Subject: Application no. EP/179/18/PL Demolition of existing house & erection of 3x 3 bedroom houses together with landscaping, car parking and fencing

Dr & Mrs T Atkinson

Project: Proposed new homes; Gladwyn, The Street, East Preston BN16 1HT	
Drawing: Floor plans	
For: Mrs. J. Simmonds & Mr. P. Beamish	
Drawn: PKS	Date: November 2018
Scales: 1:50	No: 2386/01/01
To scale when printed on A3

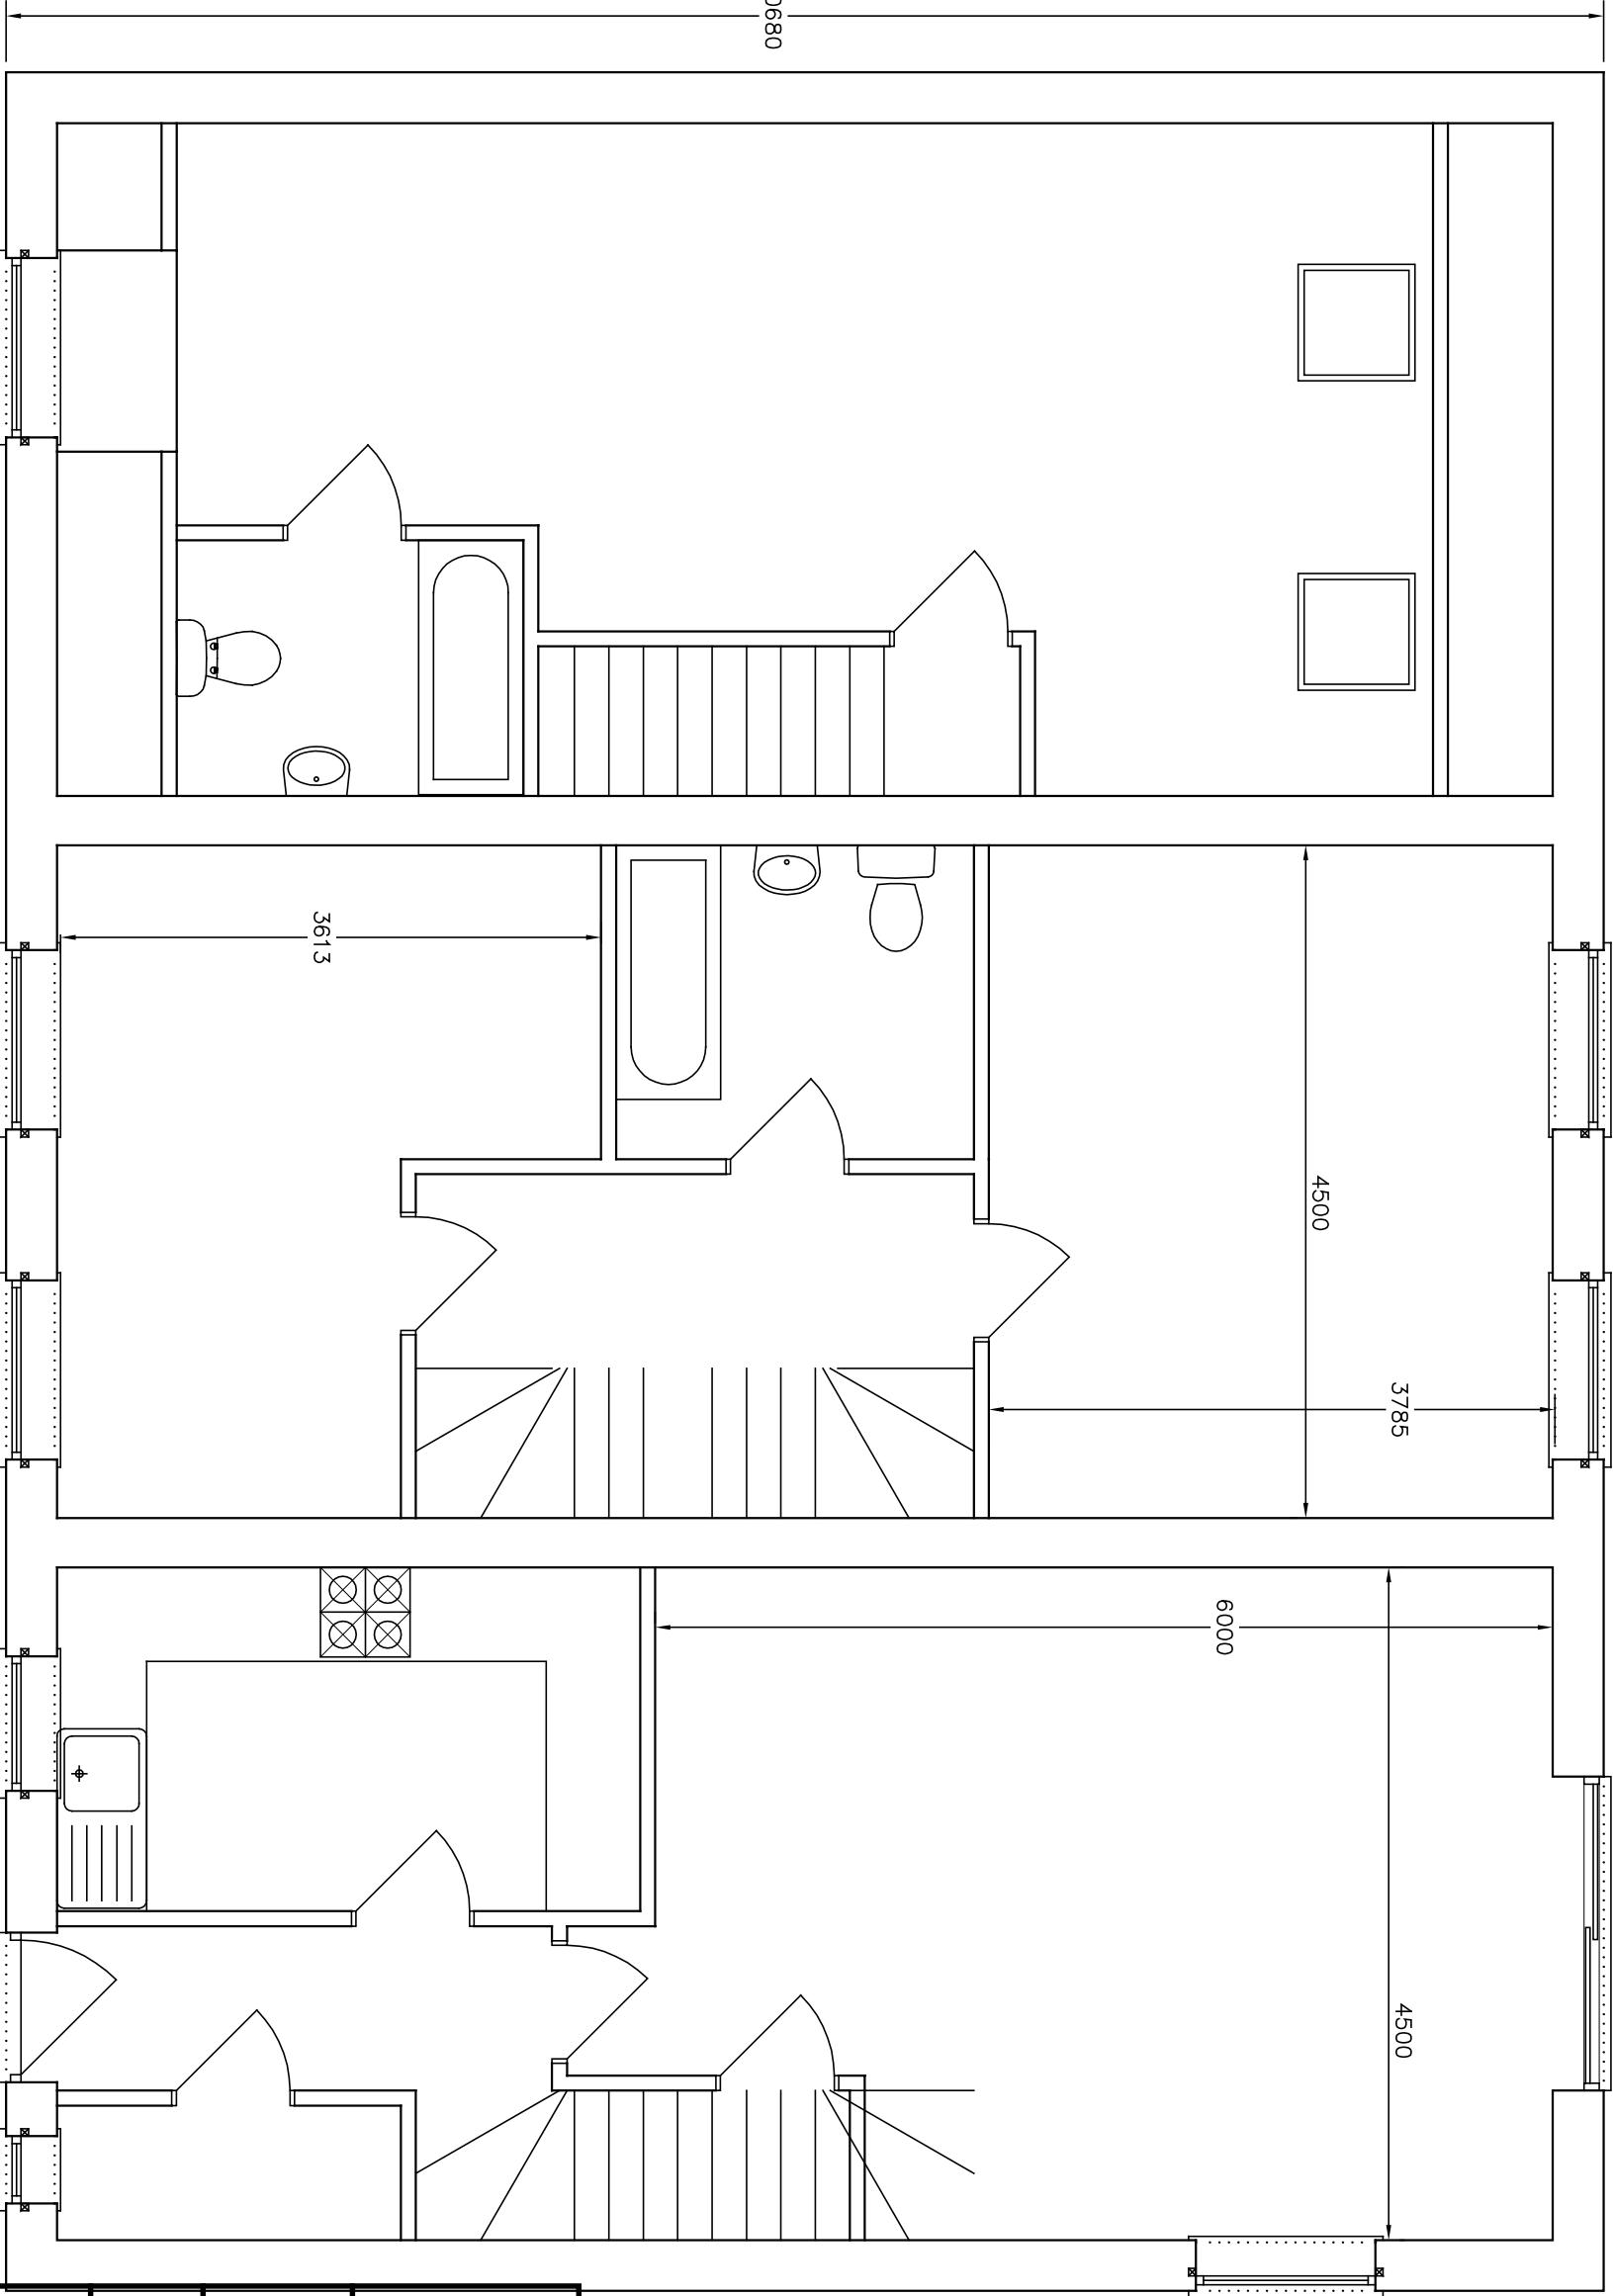
The application is for the erection of a terrace of three 2.5 storey dwellings which would be very much out of character in this location. There no similar large buildings in this area (which includes the settings of at least two and possibly three listed buildings, Wisteria Cottage, Forge Cottage and Appletree/Jasmine Cottages) and it would have an overbearing effect on nearby properties, not least the adjoining bungalow No. 5 Forge Site.

The application fails to address either of these issues. The 4 parking spaces proposed are clearly insufficient for 3x 3 bedroom houses and would inevitably lead to potentially hazardous overspill parking on The Street obstructing the driveways of those houses opposite or in Lime Tree Close where there is insufficient parking available as it is. Were additional parking to be made available on site it would simply turn the front of the property into a car park unsightly to all and particularly affecting the settings of the listed buildings.

Drawing: Street scene

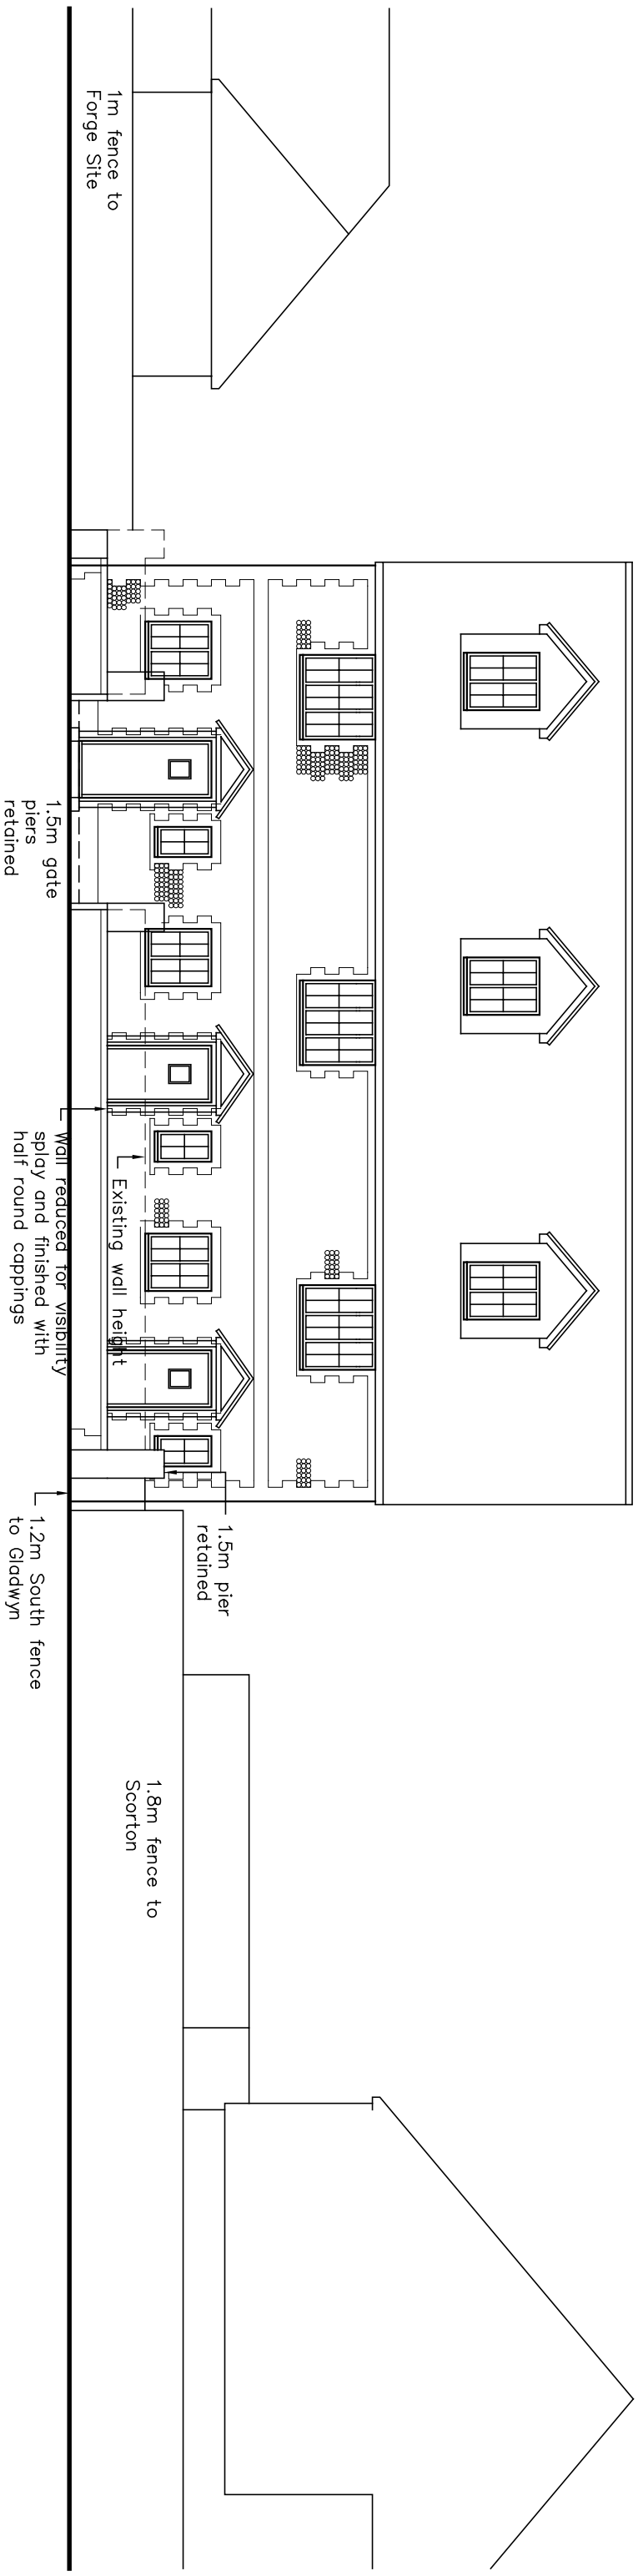
The village design statement actually uses a photo of a 2.5 storey house with dormer windows at the front even smaller than that proposed as an example of an overbearing building.
